Our ref: B/25/0225

**Re: EN 010151 - Beacon Fen Energy Park**

**Boston Borough Council's - Deadline Two Submission - 21<sup>st</sup> October 2025.**

DO NOT SCALE FROM THIS DRAWING

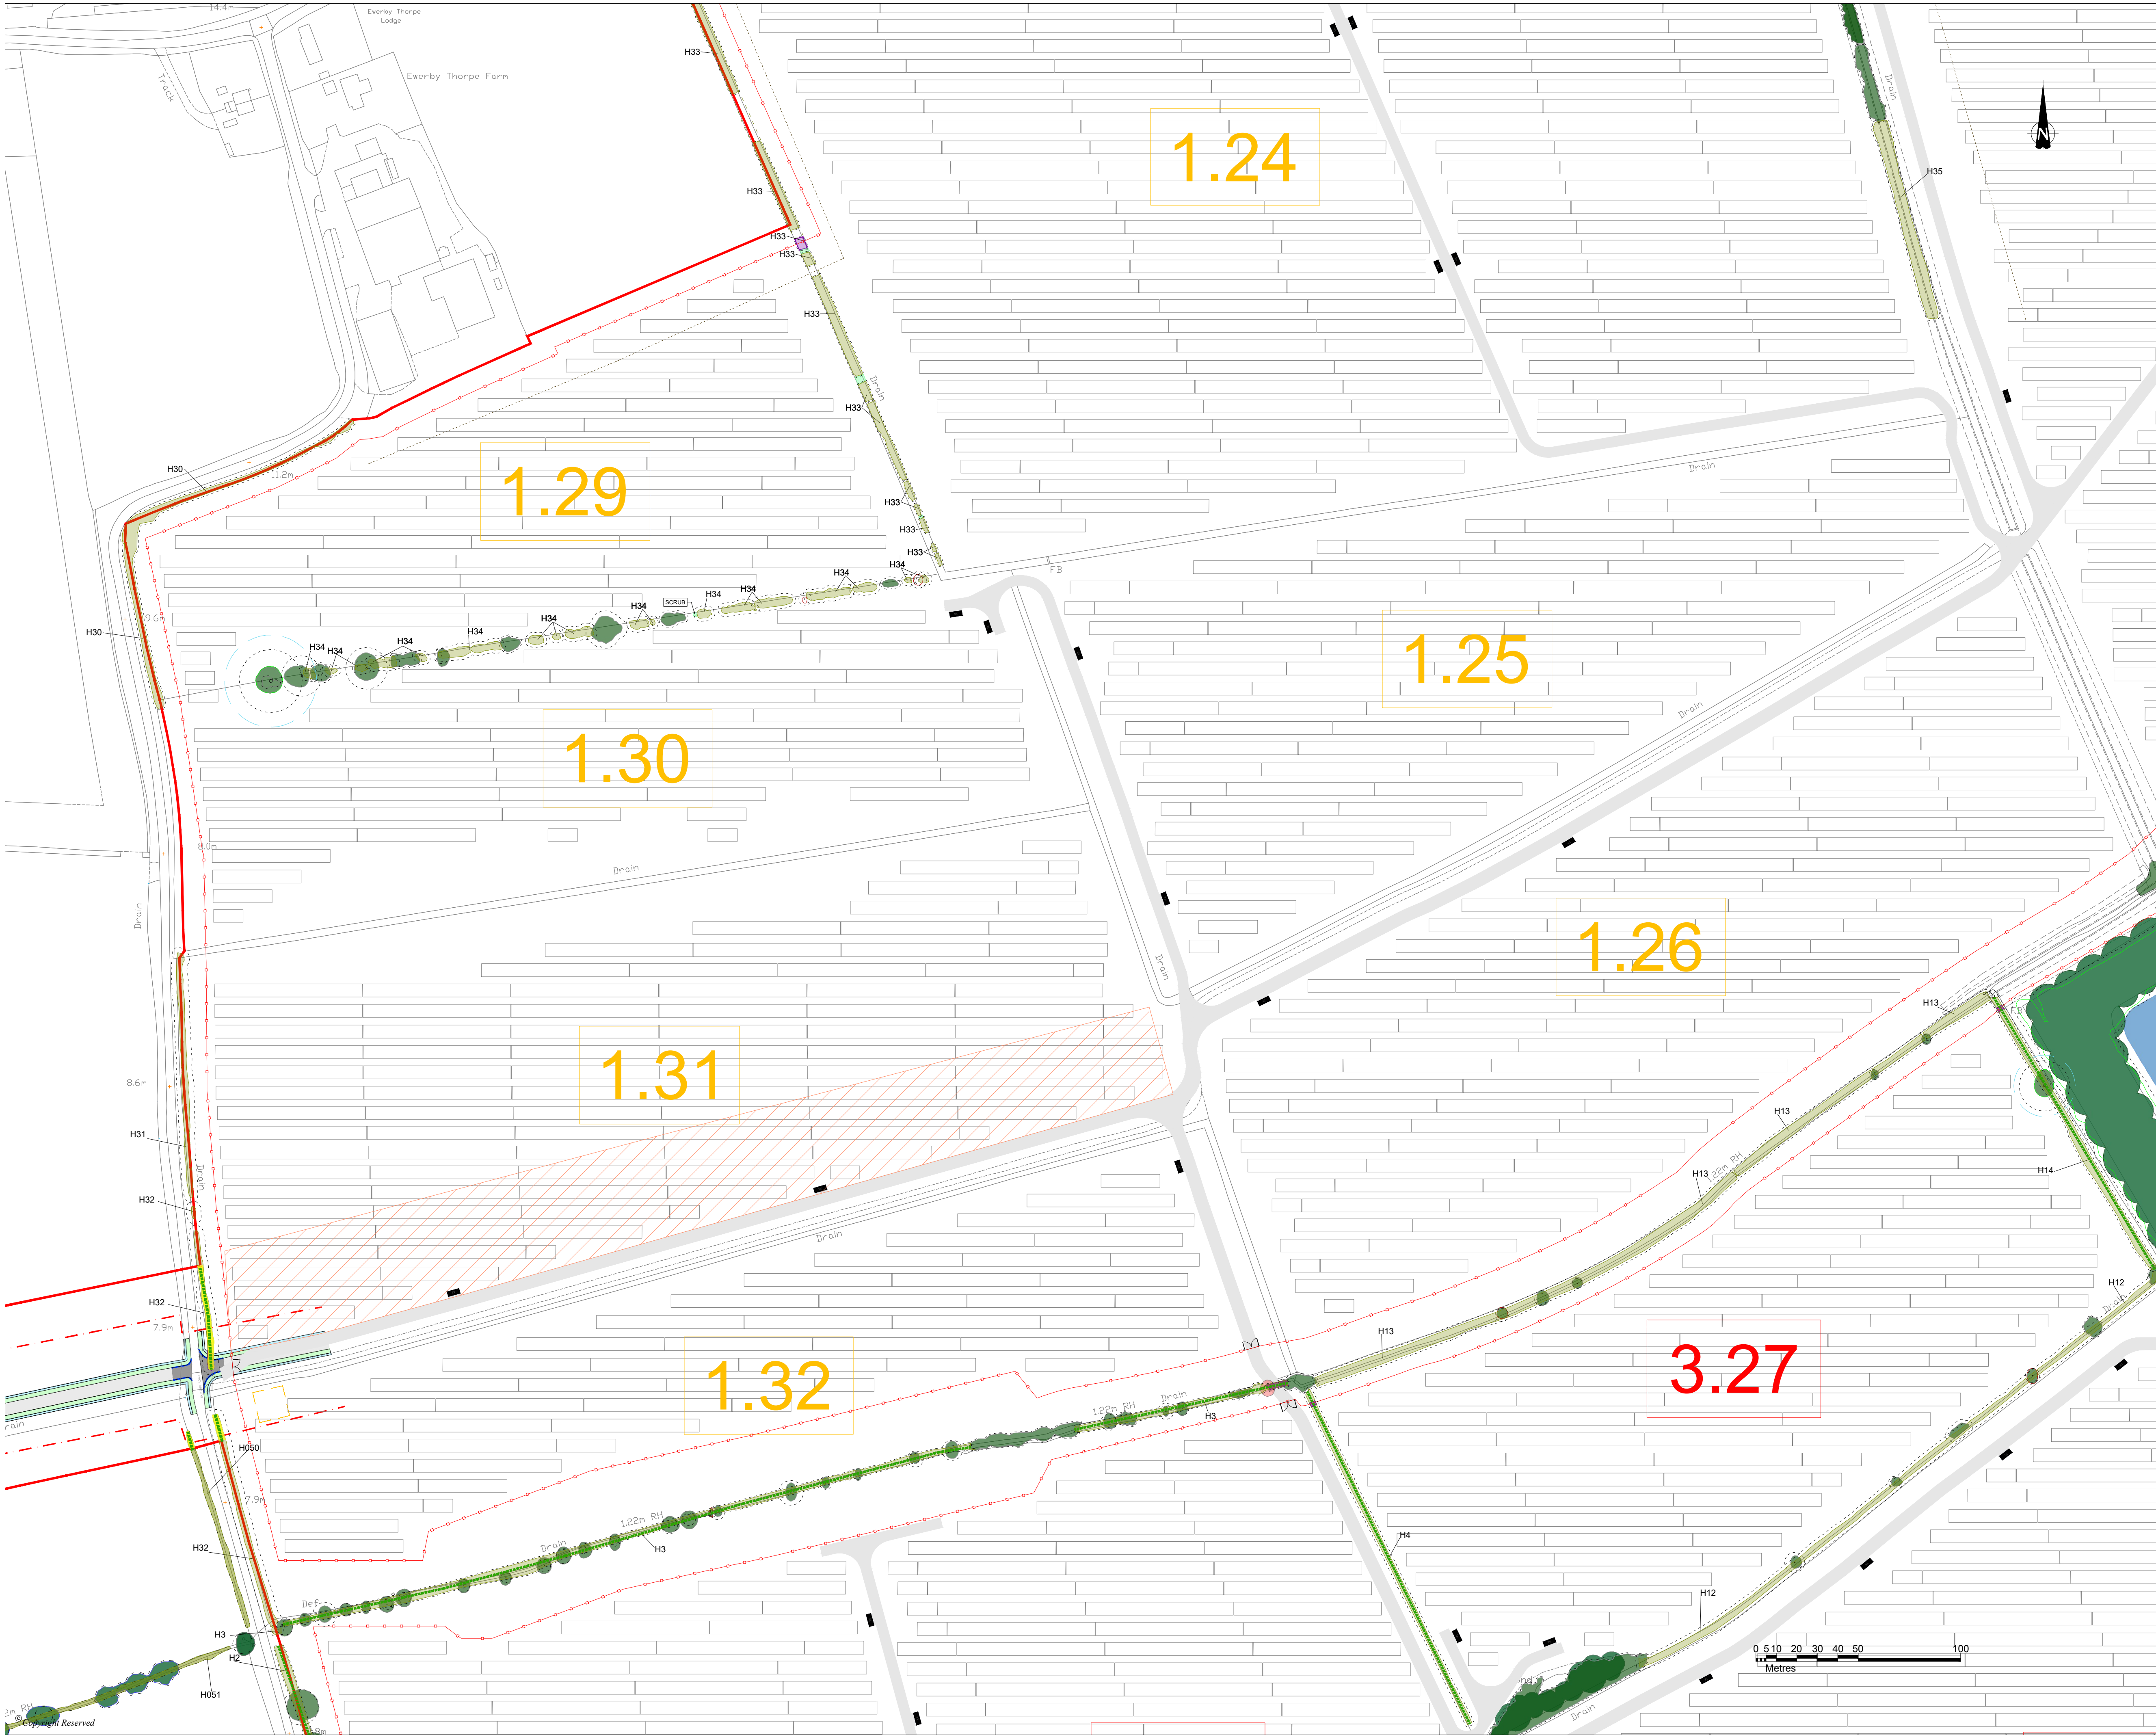
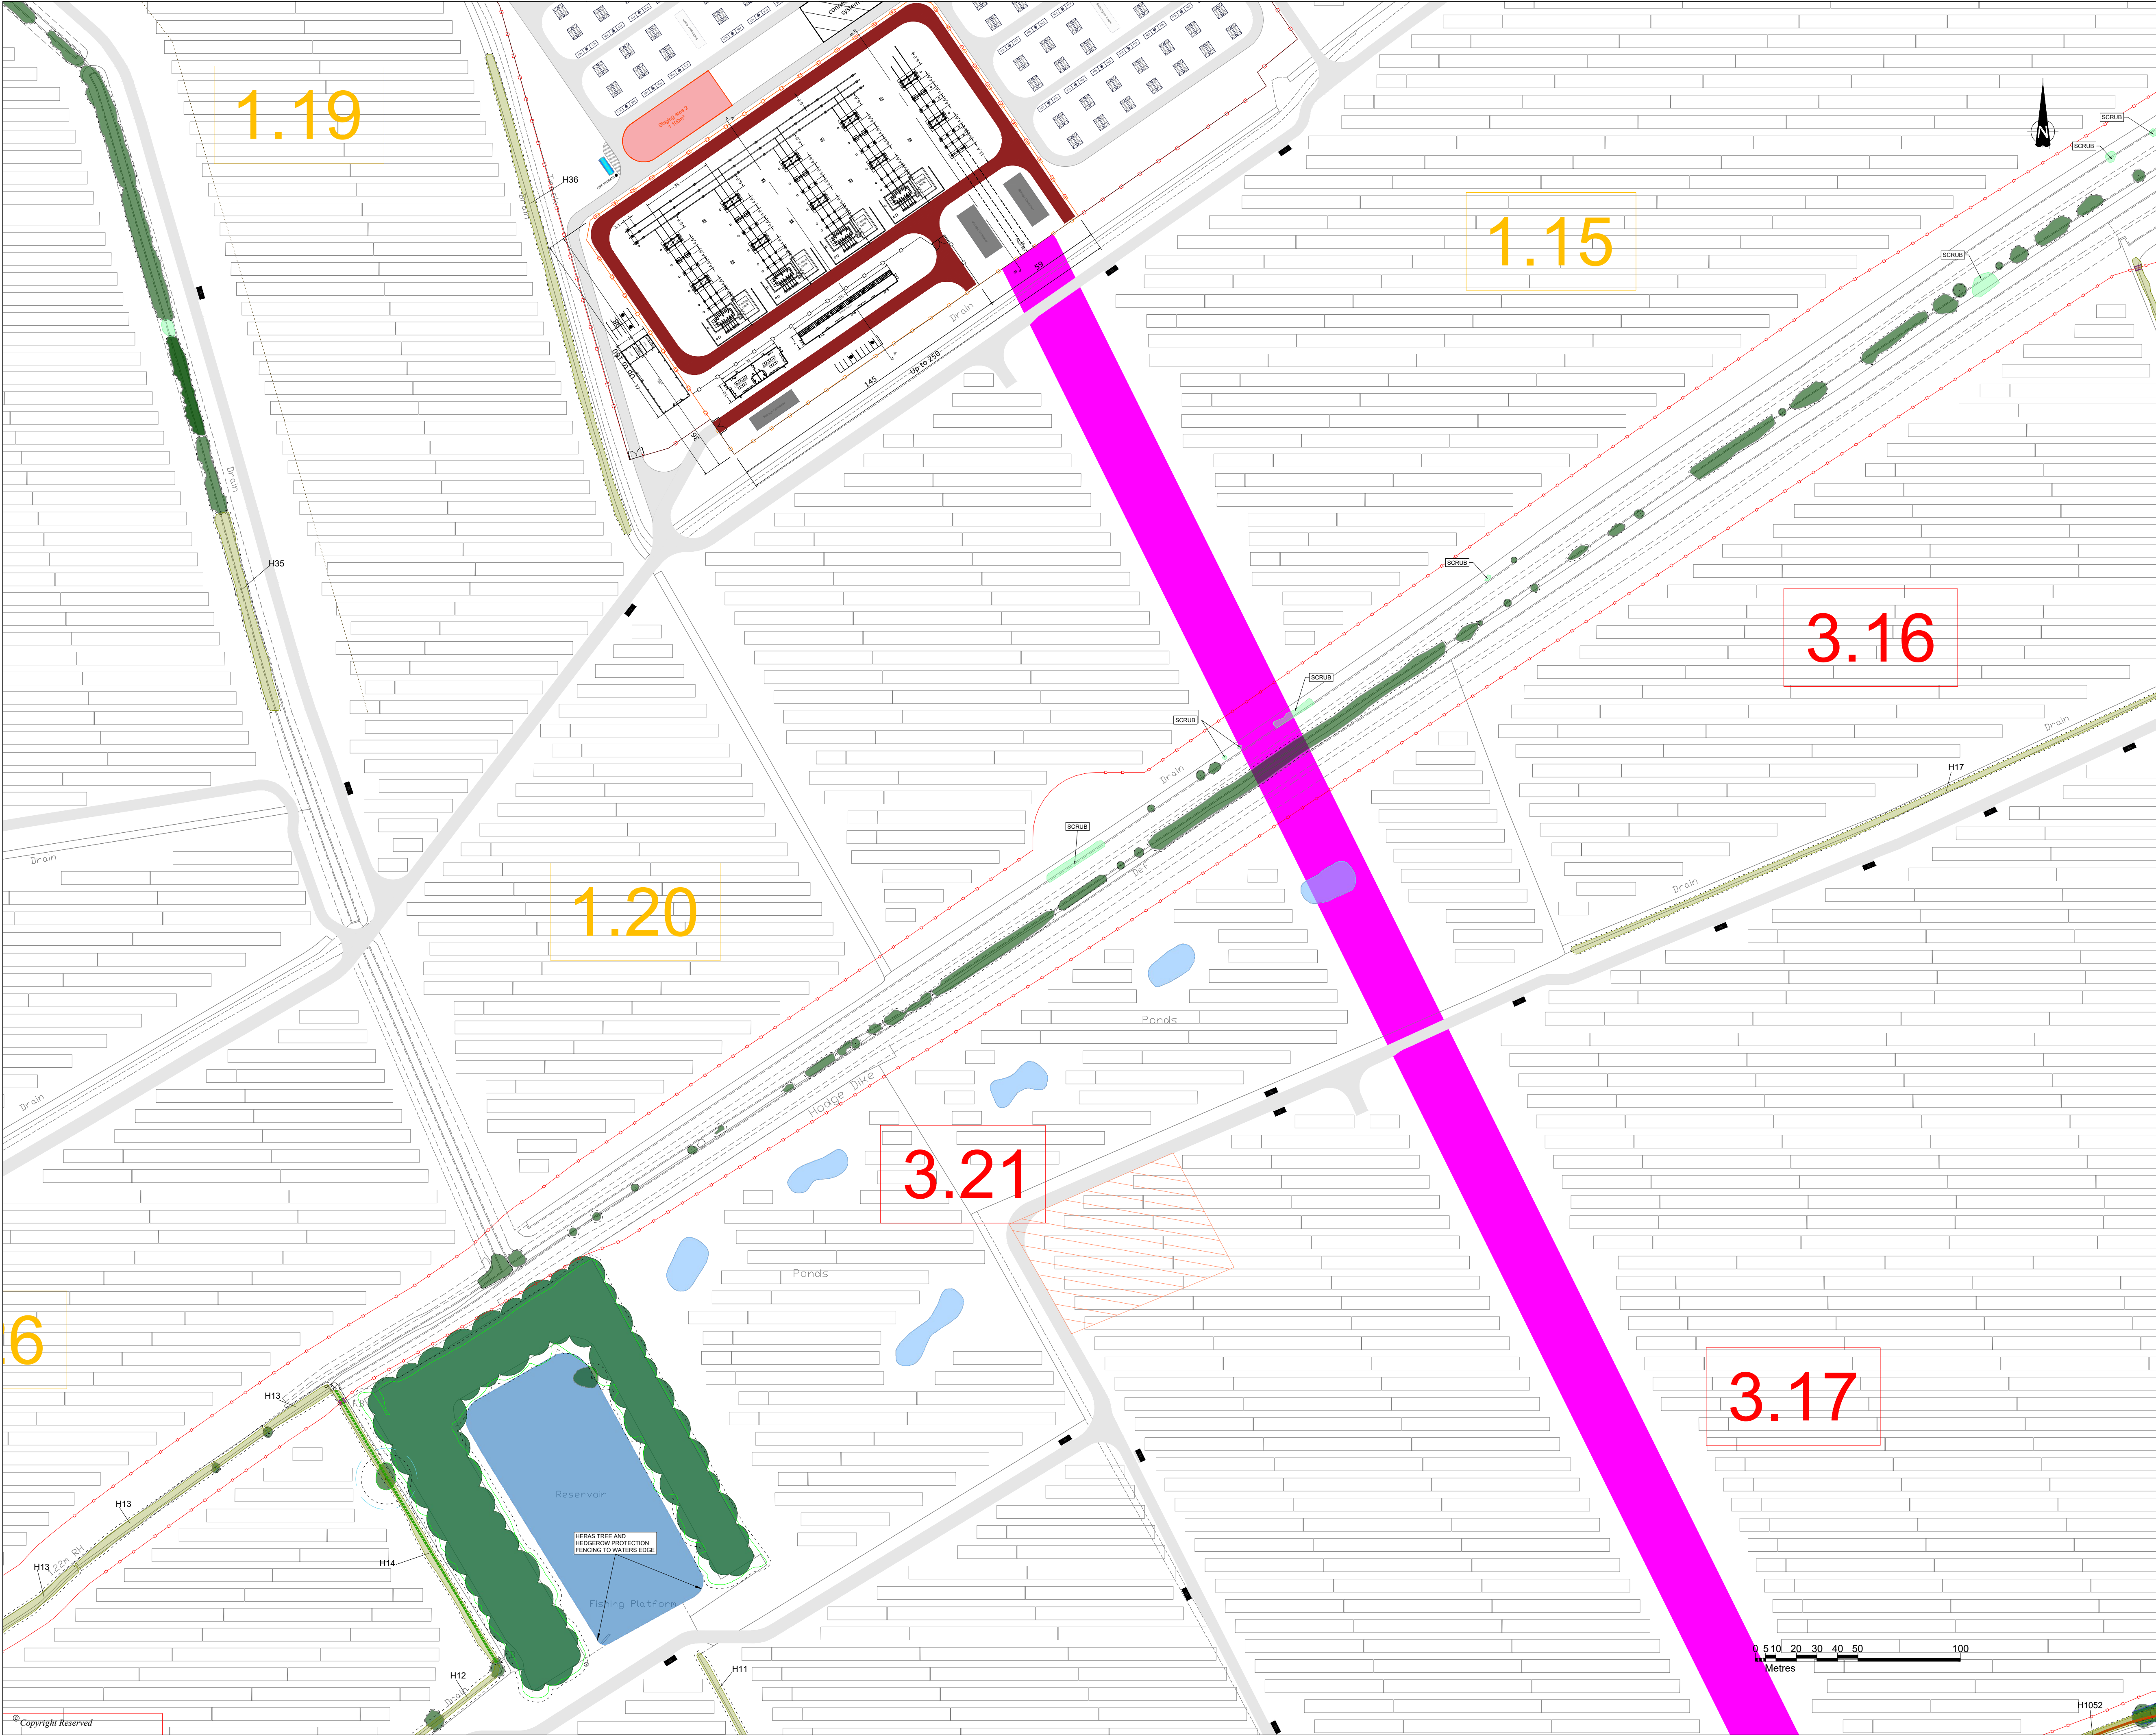
BBC welcomes the Applicant's update to Figure 6.32 Vegetation Removal Plan (REP1-015) that provides the following clarification;

- that there will be no requirement to remove existing vegetation within the South Forty Foot Drain; and
- of the extent of potential vegetation removal and retention at Bicker Fen Substation.

BBC seeks further clarity on how the vegetation shown as retained on the updated Vegetation Removal Plan and the Vegetation to be removed are secured within the Requirements of the draft DCO.

BBC wishes to ensure that vegetation shown as retained on the updated Vegetation Removal Plan and the Vegetation to be removed are secured and approved by the relevant Planning Authority within the Requirements of the draft DCO.

As noted above the Applicants update to the Vegetation Removal Plan is welcomed and provides the necessary clarity at this location provided that vegetation shown as retained on the updated Vegetation Removal Plan are adequately secured and that they will be approved by the relevant Planning Authority within the Requirements of the draft DCO.
